Application by East Anglia Limited

East Anglia THREE Offshore Wind farm

The Examining Authority's first written questions and requests for information

Issued on Wednesday 6 July 2016

East Anglia THREE Limited Sediment Contamination Sample Sites			
Volume 2		Figure 8.1	
Layout	Date	Rev	Dwg No.
N/A	19/10/2015	2	EA3-O-026

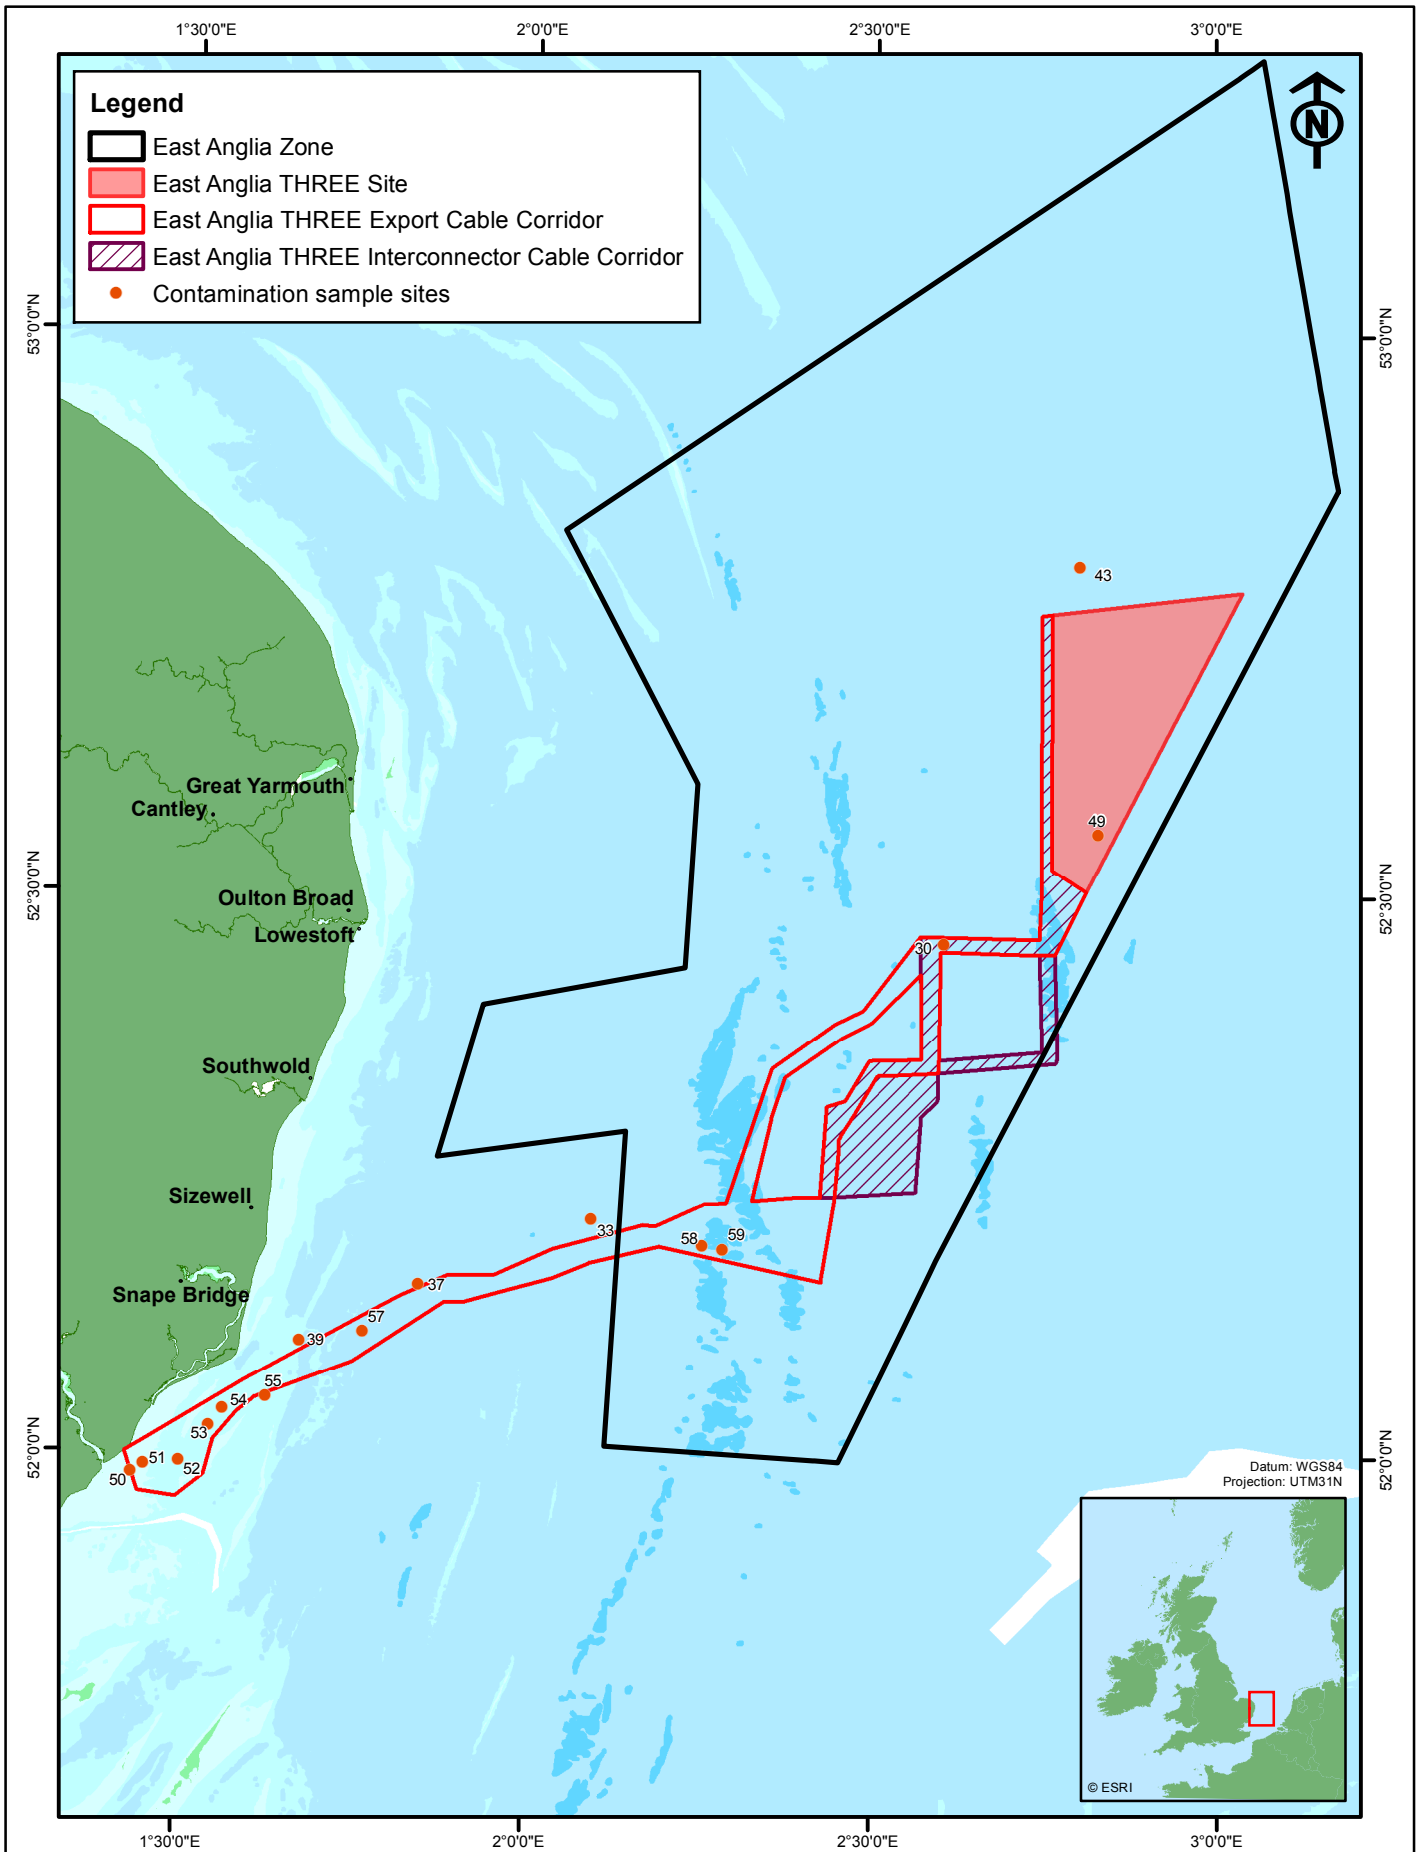
Question to:		Question:
		5.4.2 of its RR [RR-003]?
BE5	Applicant, NE, MMO	<p>The Applicant includes the following as embedded mitigation in ES Chapter 10 [APP-118]: <i>"Should dredging be required in the vicinity of station 30 (see Figure 8.1) where elevated levels of arsenic have been detected, EATL would collect further data to assess the extent of the affected area and if found to be extensive would agree with the MMO a strategy for the disposal of material from this area to minimise impacts"</i>.</p> <p>Could the Applicant comment on whether it intends to secure this embedded mitigation through the draft DCO or DMLs, as appropriate?</p> <p>NE, in RR-003 paragraph 5.4.3, considers that a monitoring method for recording elevated levels of arsenic should be included in the IPMP. Could the Applicant confirm whether it intends to amend the IPMP to include for such monitoring?</p> <p>MMO, in its RR [RR-031], requests that this area (Site 30) be excluded from any dredge and disposal granted by this licence. It goes on to state that should dredge and sediment disposal become necessary in this area, additional marine licence applications will be required and onshore disposal considered.</p> <p>Could the MMO confirm whether the Applicant's ES sufficiently assesses the implications of dredge and disposal in this area, including the necessary mitigation measures to do so?</p>

Question to:		Question:
		<p>Could the Applicant and the MMO provide an update with regard to any agreements reached in respect of Site 30, including any proposals to exclude this area from dredge and disposal consent? Could the Applicant and MMO also comment on how such restrictions would be secured through the DCO/DMLs?</p>
BE6	Applicant, NE, MMO	<p>NE, in RR-003 paragraph 5.4.4, discusses the status of Orford Inshore recommended Marine Coastal Zone (rMCZ). Can NE provide an update on the status of Orford Inshore rMCZ?</p> <p>NE states in its RR that "<i>Recommended MCZ are a material consideration in the marine licensing process</i>" and also that "<i>Orford Inshore rMCZ contains a features (subtidal mixed sediment) that may be affected by cable installation, operation and decommissioning.</i>" The Applicant states at paragraph 143 of ES Chapter 10 [APP-118] that "<i>...at this stage the Orford Inshore recommended MCZ is not being considered for designation and therefore in line with guidance provided by the MMO it is not considered within this EIA.</i>"</p> <p>Could NE and MMO comment on whether the Applicant would be required to undertake further assessment for the marine licence in respect of the rMCZ? In NE's opinion, does the Applicant's ES adequately assess the feature (subtidal mixed sediment) of the rMCZ? Does NE have any outstanding concerns with regard to effects on the rMCZ as a result of the proposed development?</p>
